**DISAPPROVED**  
Plan Review  
08/13/2019 3:36:26 PM  
dsdarchuleta  
EPC Planning & Community  
Development Department

**SFD191026**  
**PLAT 14238**  
**PUD**

THE  
**MARSHALL RESIDENCE**  
15051 LONGWALL COURT  
FLYING HORSE NORTH, FILING #1, LOT 46  
COLORADO SPRINGS, CO 80908 - EL PASO COUNTY

CONSTRUCTION DOCUMENT SET  
SITE PLAN  
FOX BIRD MODEL  
CRAFTSMAN ELEVATION

SHEET NUMBER
A1.1

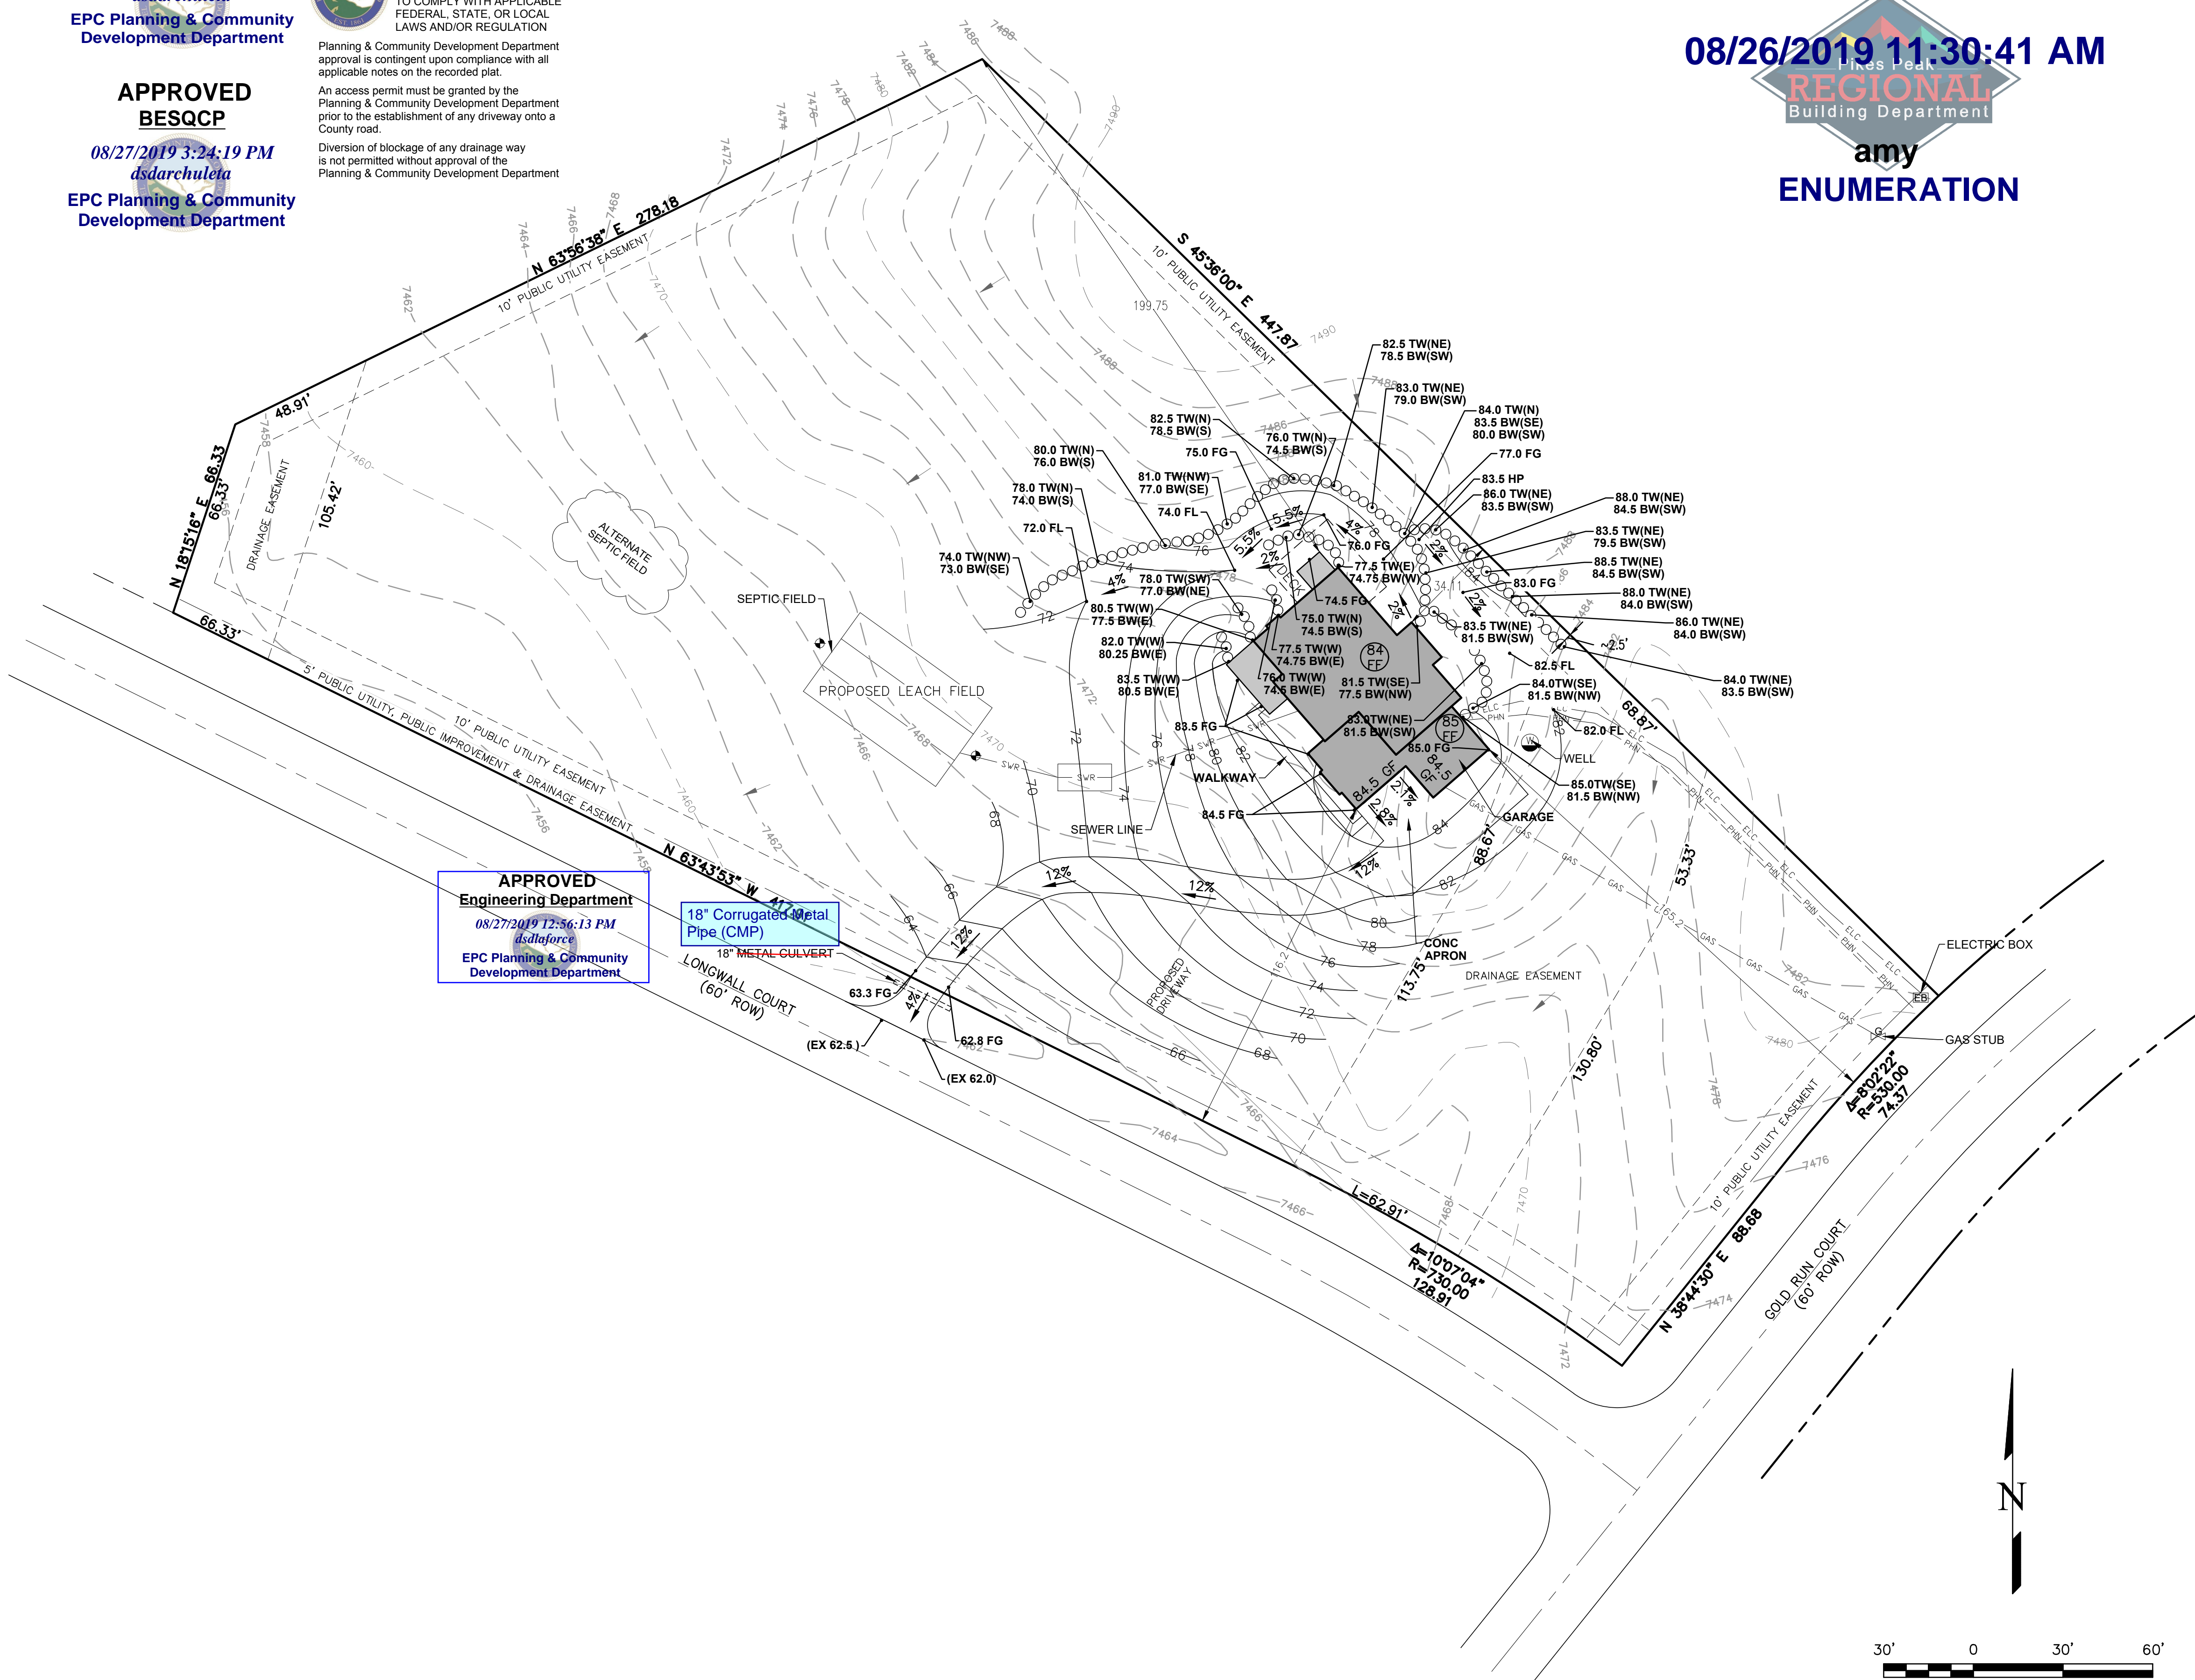
- 1) ENGINEER REVIEW DISAPPROVED
  - 2) MISSING DISTANCE MEASUREMENTS OF PROPERTY LINE TO STRUCTURE
  - 3) SHOW DRAINAGE EASEMENT MEASUREMENTS
- NOTE: RETAINING WALLS OVER 4' REQUIRE A BUILDING PERMIT

When sloping towards the road, driveways shall have a maximum grade of 4 percent for a minimum of 20 feet. Update to provide spot elevation at the edge of Longwall Court and at the gradebreak.

add an abbreviation list. What is MTL? Acceptable culvert pipe material is corrugated metal pipe (CMP) or reinforced concrete (RCP).

distance measurement required property line to structure

retaining walls over 4' require a building permit

Applicant will need to obtain permission or temporary construction easement from the adjacent property owner if construction disturbance occurs off-site.

**SHOW DRAINAGE EASEMENT MEASUREMENTS**
